Application No: BE/36/21/HH
Site Address: 32 Norbren Avenue Bersted PO21 5HE
Description of works: Two storey and single storey rear extension, part first floor side extension, conversion of roof from hip to gable end and dormer.

Thank you for your internet representation made on 10th May 2021 which has been recorded as an objection with the comments as follows:

I am writing to register my objection to the proposed house extension (planning application BE/36/21/HH and the amended plans submitted on the 4th May 2021).

GROUND FLOOR - EXISTING

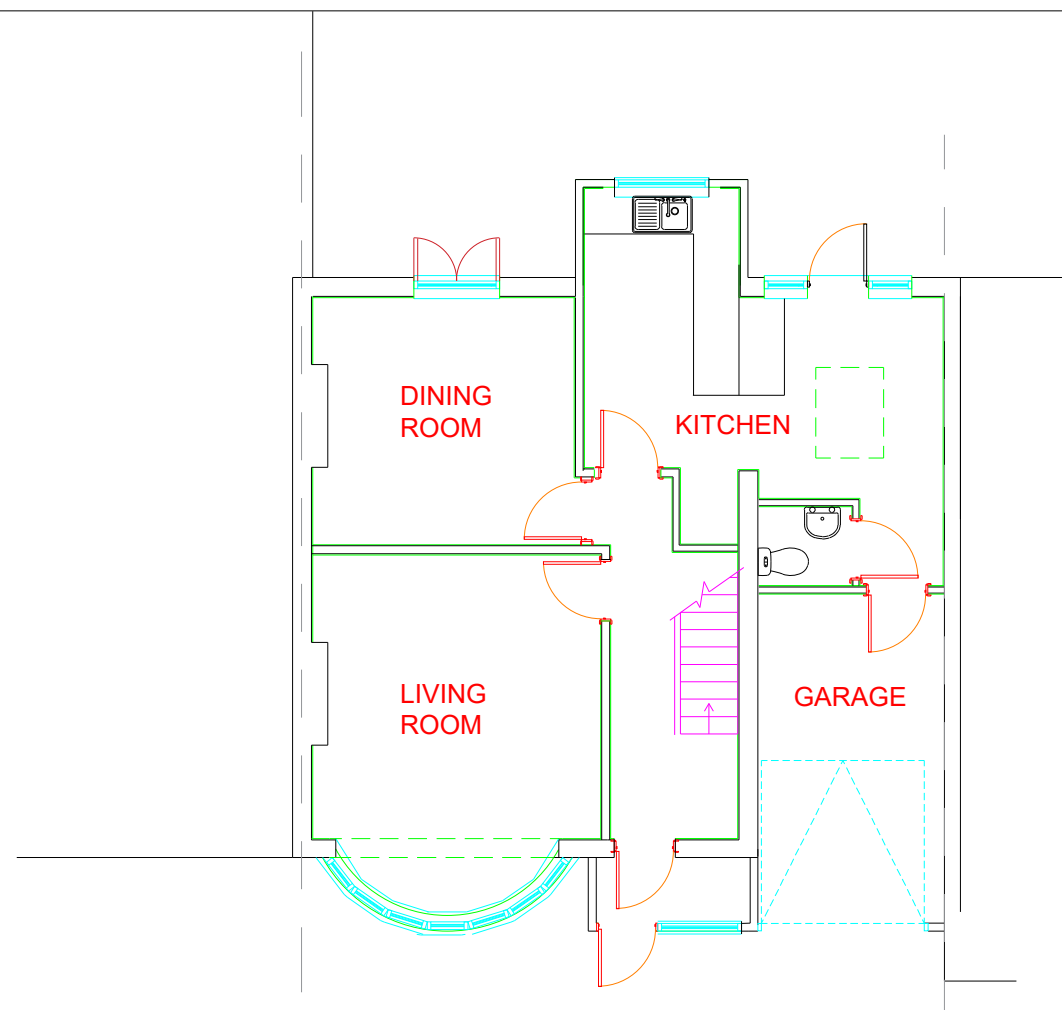
I still remain concerned about the accuracy of the plans as they show chimney breasts in the living room and dining room. We believe all the chimney breasts were removed from the property 12-18 months ago. The chimney stack is being supported by cantilevers from the semi-detached dividing wall in the loft area. Therefore with this large loft extension work I would need assurance that the structure of the semi-detached building is sound. No doubt this will be taken into account under the building regulations.

SOUTH (REAR) ELEVATION
PROPOSED

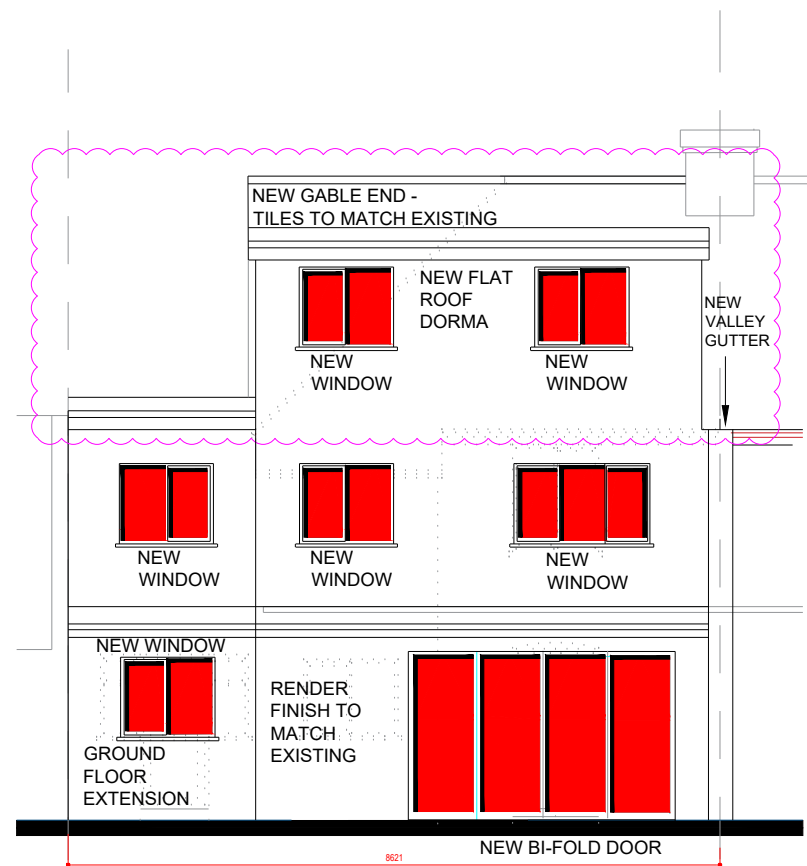
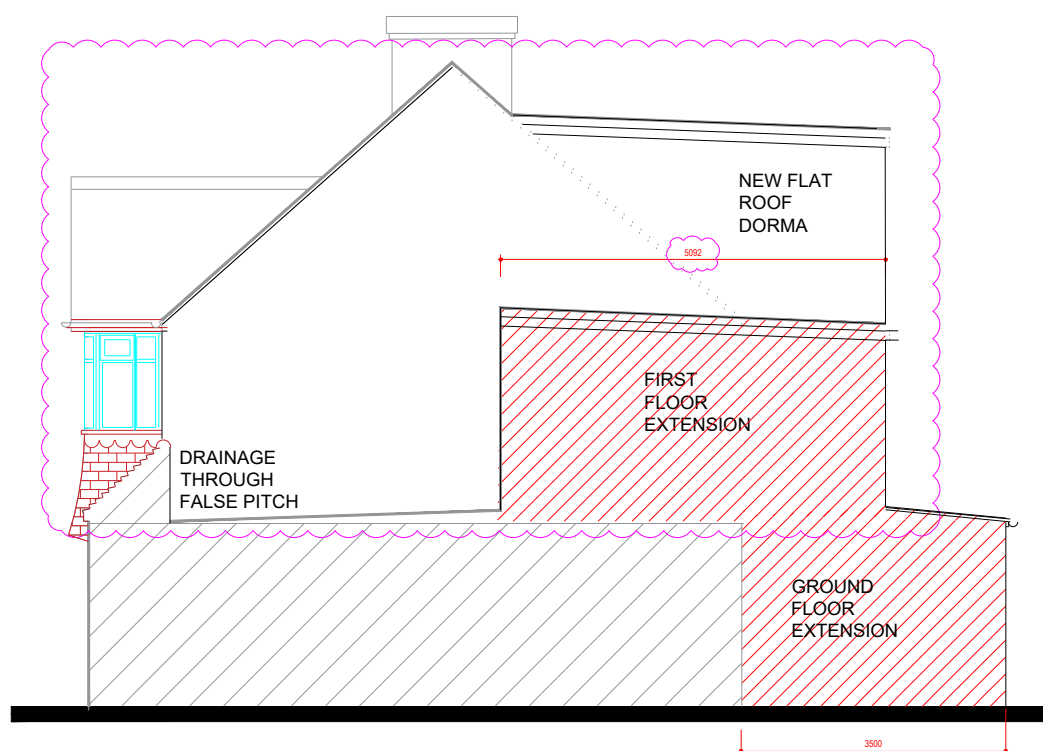
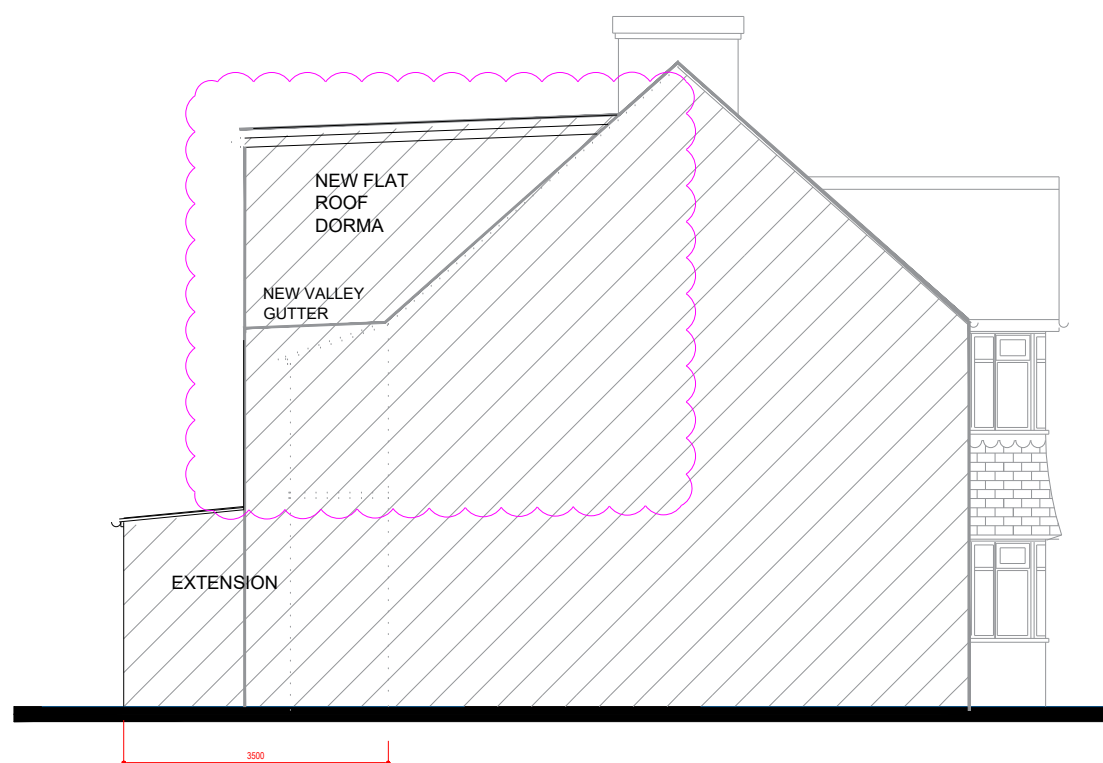
The extension at the rear of property No 32 being two stories high would create a 1.9m X 4.5m wall immediately next to our rear bedroom window. This wall immediately next to our property would not only cause a loss of light to the rear bedroom, the dining room and conservatory but would also be a massive eyesore when looking out of the bedroom window. I understand that no one is entitled to a view, however, in this case what is proposed is so close and imposing that it will actually dominate the view.

The proposed rear extension which now incorporates a second floor will total dominate our garden. Also with the additional windows on the second floor level this would compromise the privacy of our and neighbours gardens in the vicinity of the proposed extension.
